WELWYN HATFIELD COUNCIL – DEVELOPMENT CONTROL
DELEGATED REPORT

APPLICATION No:	S6/2007/1503/FP
------------------------	------------------------

The application seeks full planning permission for demolition of the existing garage and erection of a two storey side extension with dormer windows.

Drawing Proposed Scheme
 Plans and Elevations

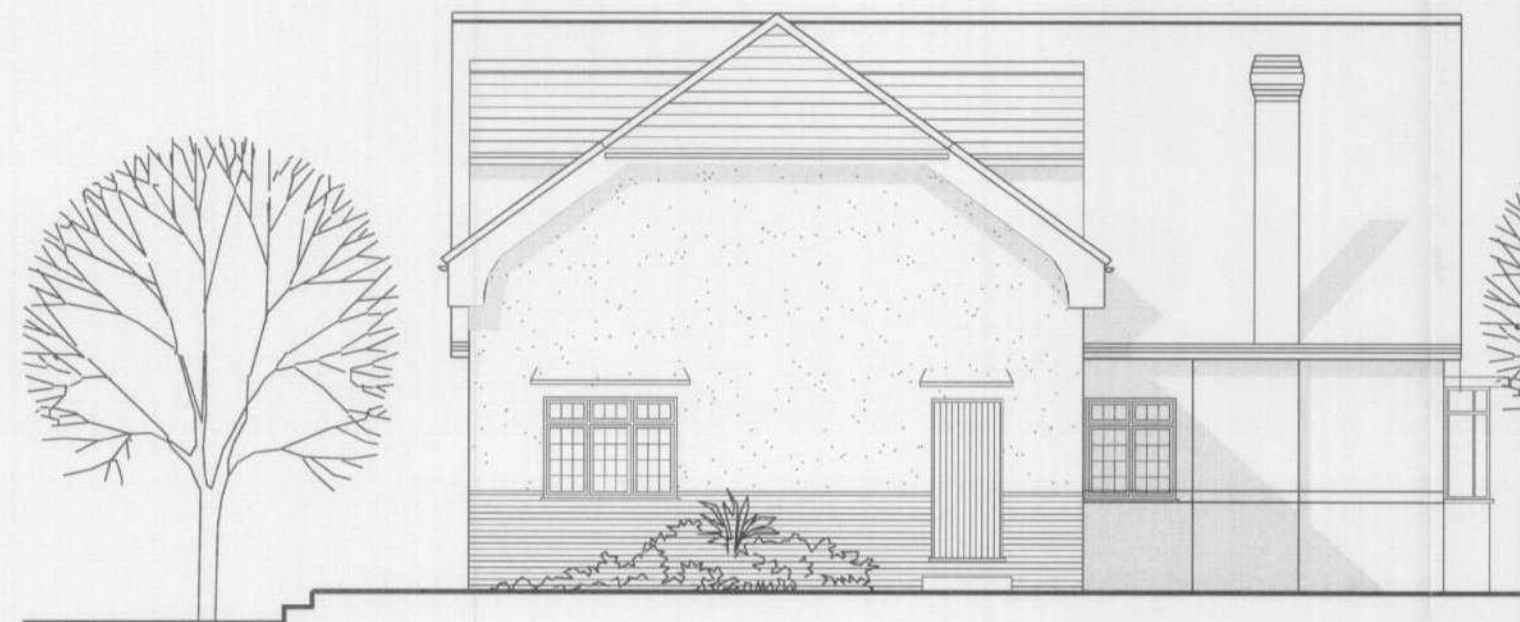
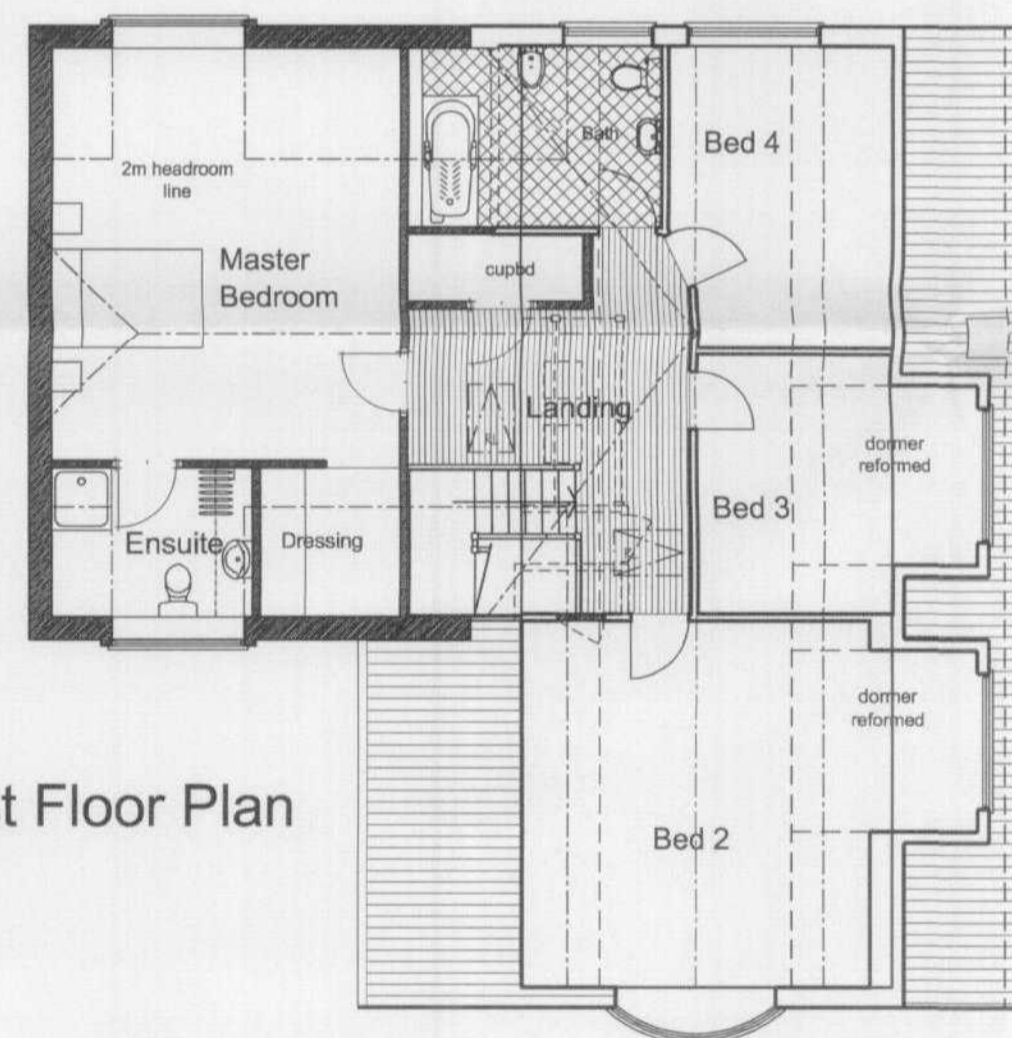
From looking at the figures it is considered that an increase in floorspace of 114 sq.m (68%) and footprint of 61 (58%) are considered to be disproportionate to the original dwelling and therefore fail to comply with section (i) of Policy RA3 (Extension to Dwellings in the Green Belt).

However, it is also important to consider the overall visual impact of the extension in relation to its prominence, size, bulk and design on the openness of the Green Belt. It is acknowledged that there is an existing garage on this side elevation, which would be demolished and the proposed side extension would be relocated further to the rear of the site by approximately 4 metres. Consequently, a proportion of the ground floor aspect of the extension would be constructed within a similar footprint although within a slightly varied location to the existing garage with a similar floorspace. However, the erection of a first floor side extension would have a significant visual impact on the openness of the Green Belt and would close up an existing visual gap above the existing garage. The extension would be prominent due to its size, bulk and design of the two storey extension and the insertion of additional dormer windows would add additional bulk to the roof slope. This fails to comply with Section (ii) of Policy RA3 (Extensions to Dwellings in the Green Belt).

The proposed extension would maintain the pitch of the existing roofline with a continuation to the east elevation. This would be finished with a gabled end with a hipped top section. This is considered to be appropriately designed and would respect and relate to the original dwelling and character of the street scene, particularly given that a relatively low eaves height (although approximately 1.5 metres higher than the eaves height of the front gable) and dormer windows would be maintained. The immediate street scene contains a number of chalet style dwellings and it is considered that the proposed dwelling would reflect the existing architectural pattern within the street scene. This complies with Policies D1 and D2 of the Welwyn Hatfield District Plan 2005 and material contained within the Supplementary Design Guidance 2005.

The proposed dormer windows comply with Section 5.1 vi of the Supplementary Design Guidance as they are located below the ridge height, in proportion to the existing fenestration and 1m from the adjoining party walls. They have also been designed to emulate the existing design of the side dormer windows with a gabled

The proposed two storey side extension including dormer windows would result in a disproportionate increase in the size of the dwelling and have an adverse visual impact (in terms of its prominence, size, bulk and design) on the character and openness of the Green Belt. Consequently, this fails to comply with Policies RA1 and RA3 of the Welwyn Hatfield District Plan 2005.

1) The proposal by virtue of the size, bulk, scale and design would result in a disproportionate addition over and above the size of the original dwelling and therefore represent inappropriate development within the Green Belt. The applicant has failed to demonstrate to the satisfaction of the Local Planning Authority any very special circumstances exist to outweigh the harm caused by reason of its inappropriateness. In addition, the proposal by virtue of its siting, design and bulk would have a detrimental impact on the character and openness of this part of the

Green Belt and the visual interest of its surroundings. The proposal is therefore contrary to the advice contained within PPG2 and Policies RA3, D1 and D2 of the Welwyn Hatfield District Plan 2005.
